Our reference: DOC16/642410

EPA Air Technical Advisory Services Unit's comments on Proposed Lead Acid Battery Recycling Facility at Kurri Kurri, NSW (SSD 7520)

The EPA's Air Technical Advisory Services Unit (ATASU) has reviewed the Air Quality Impact Assessment (AQIA), *Kurri Kurri Battery Recycling Facility Air Quality and Greenhouse Gas Assessment*, October 2016, prepared by Ramboll Environ.

Figure 2-1: Project process flow chart

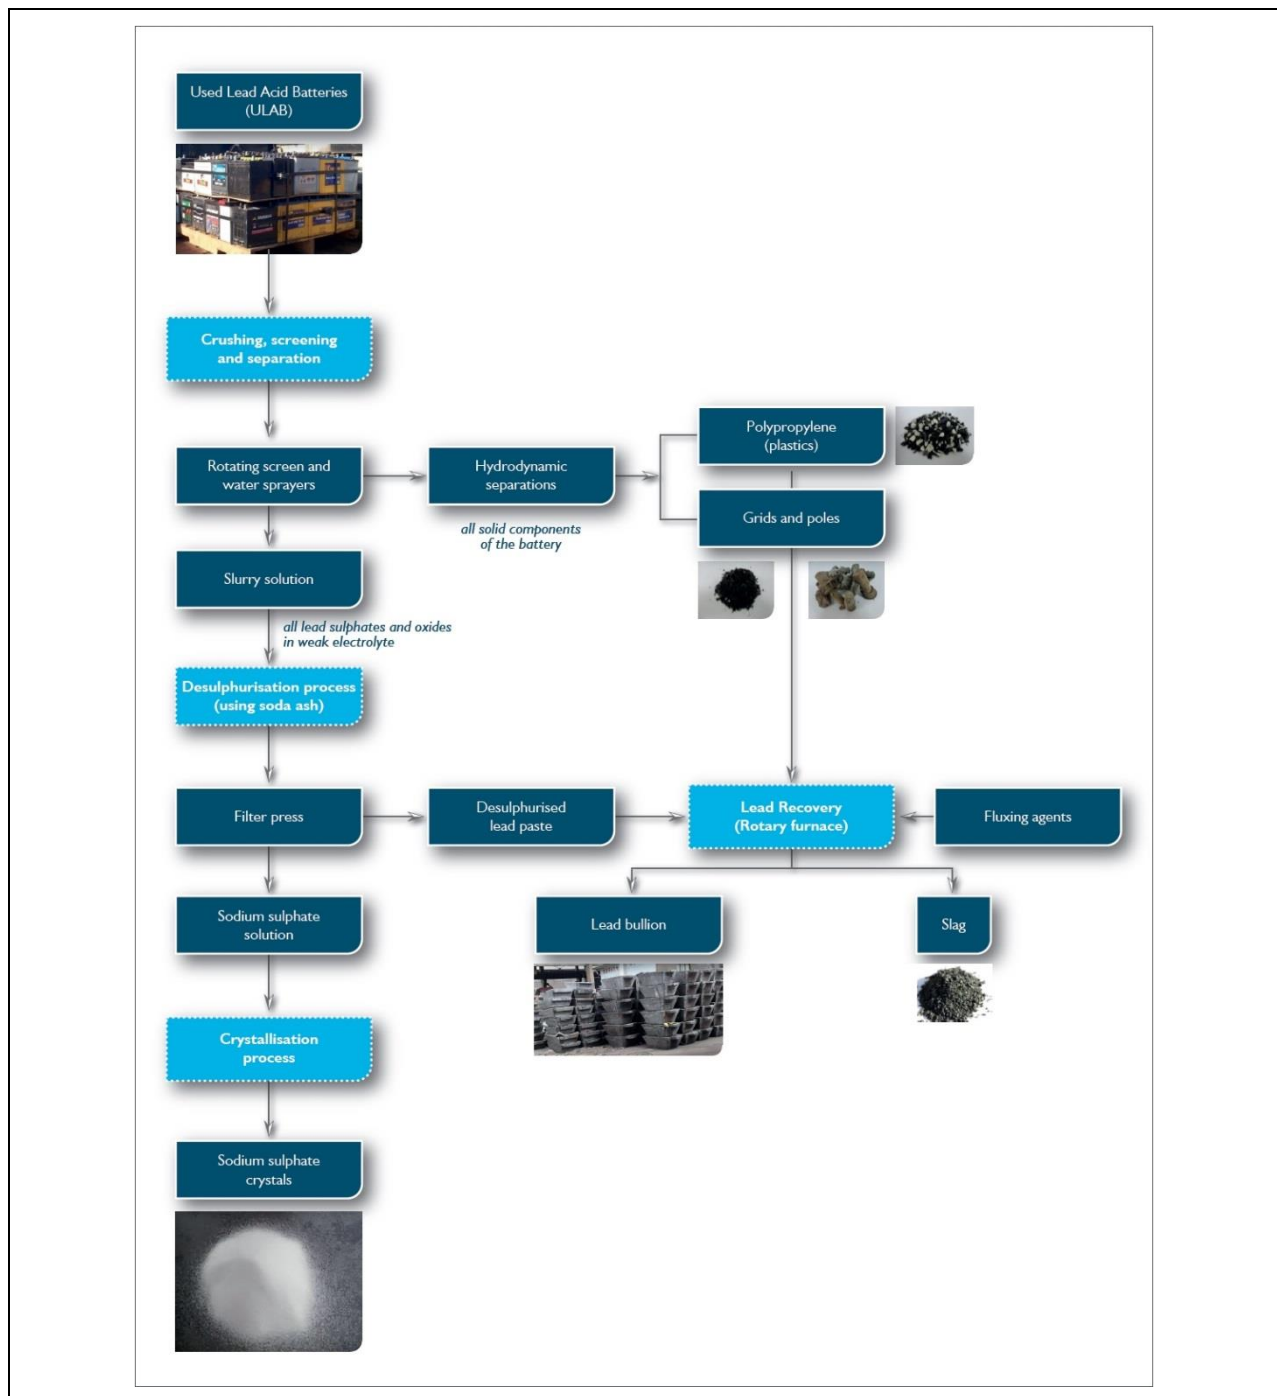
1. Description of the process lacks clarity

Section 6.1 of the Air Quality Impact Assessment (AQIA) advises there are five proposed point source emissions. The AQIA makes reference to point source discharges (stacks), C-720, C-729A, C-530, PK-520 and U-421/PK420.

Section 9.1 of the AQIA makes reference to mitigation measures and pollution control equipment, including:

- Bag house filtration system (PK-721)
- Bag house system (PK-720) for collection of process fumes from the rotary furnace;
- A pack tower scrubber (FL-530) where air collection is ducted to for removal of acid gas and mist; and
- Operation of the charge preparation building under negative pressure.

However, in some instances it is unclear which unit operations, and which pollution control equipment are associated with each point source discharge. A flow chart outlining each unit operation, the associated discharge point, and the associated pollution control equipment would be helpful in further understanding the proposal. This is an important consideration to ensure all sources, and substances are adequately characterised and assessed.

The AQIA should be revised to include information:

- ***That describes which point source emissions serve which process or unit operations;***
- ***That describes which pollution control equipment service which process or unit operations;***
- ***That describes which point sources include pollution control equipment; and***
- ***That describes which process areas are proposed to operate under negative pressure and which unit operations are contained in those process areas.***
